I am emailing to request a further EoT until Monday (22/06/2020) to allow for the sign off process. I apologise for the delay with this application. I have put the application forward with the recommendation to be approved subject to conditions having gone with option 1 of the new plans.

Further to your e mail, we have 2 options:-

1. Reduce the pitch of the extension roof so that it is 150mm below the window.
2. Keep the pitch and extend the short section of flat roof for the full width of the extension, so that it is 150mm below the window .

OPTION 1.

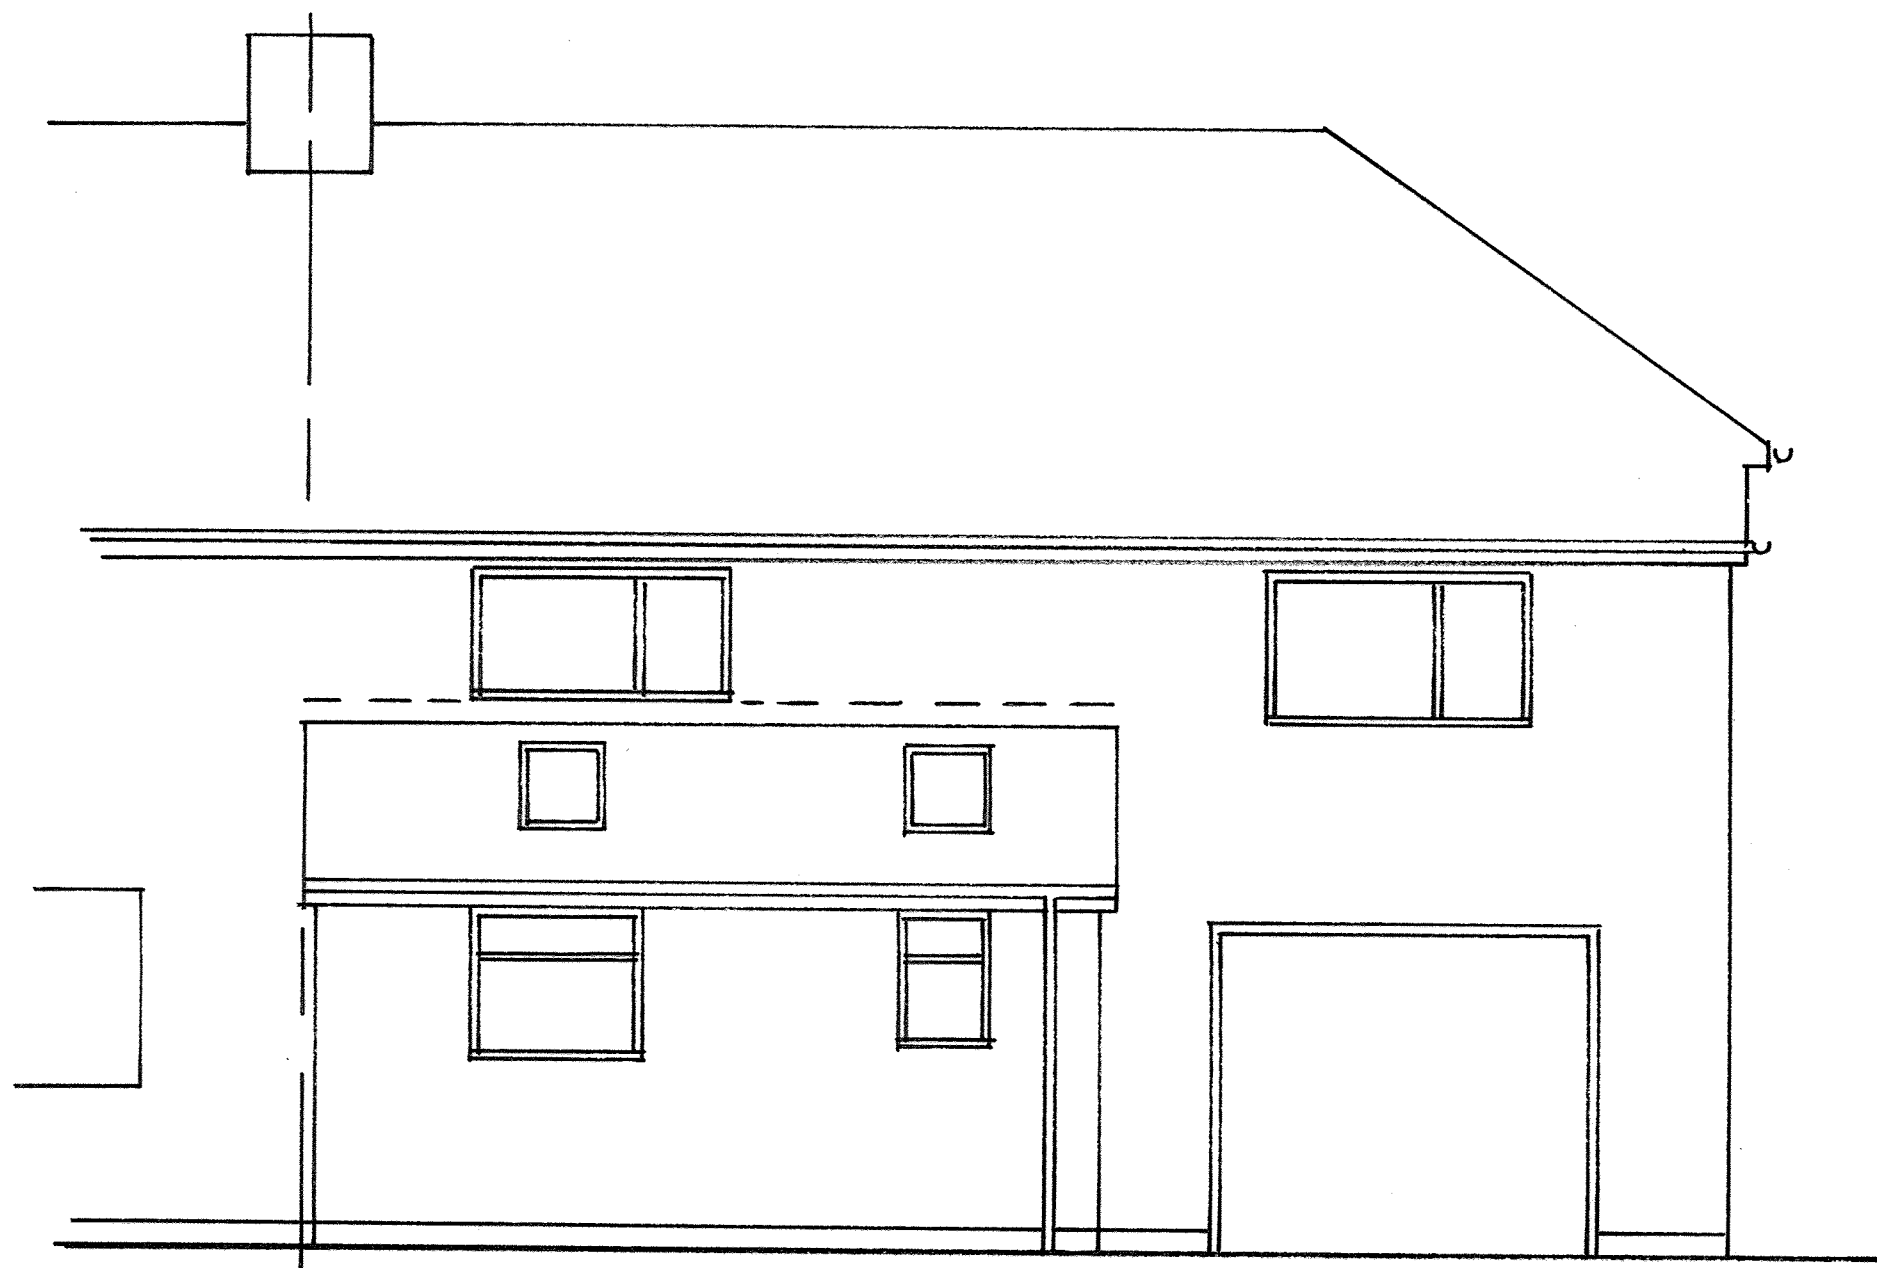
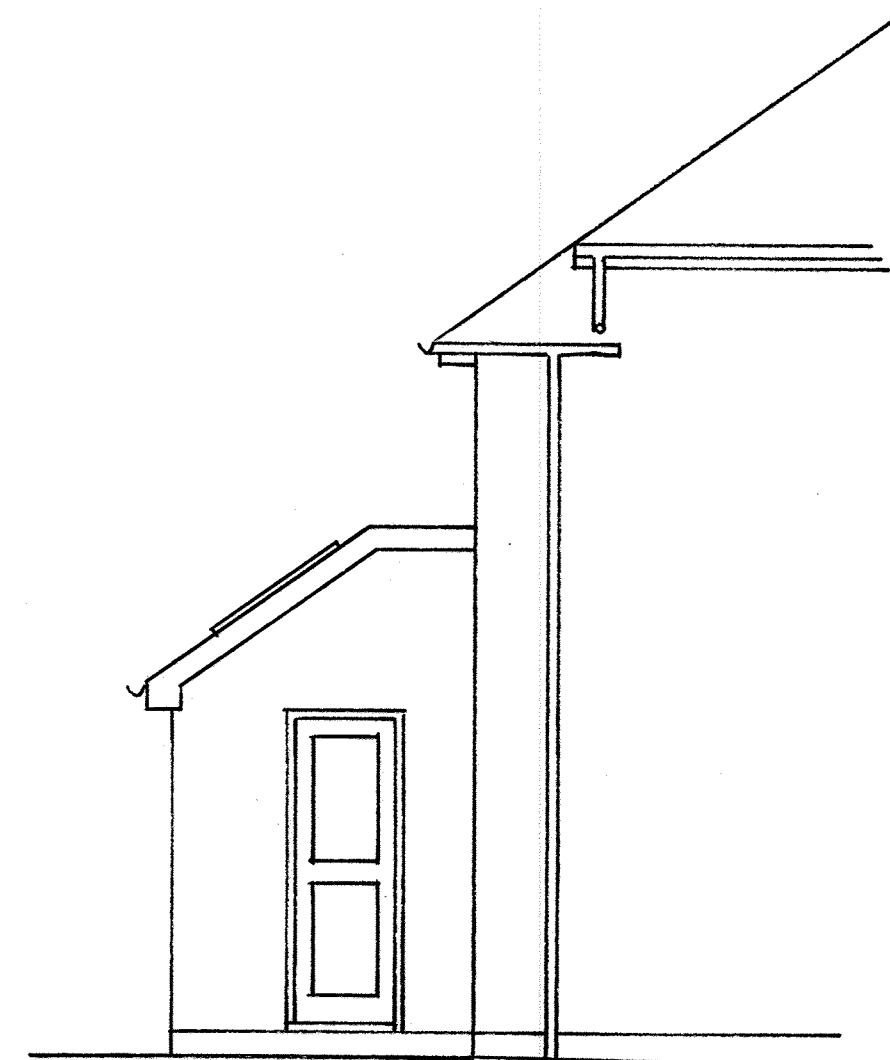
Would it be possible to have the roof of the extension straightened out so that it does not dip around the window?
If so can you send me a new plan illustrating this so that I can get this application signed off as soon as possible.

Hi Finlay,
Extension of time till the 22nd June is fine.
Option 1 is the choice.
Best wishes,
Tony.
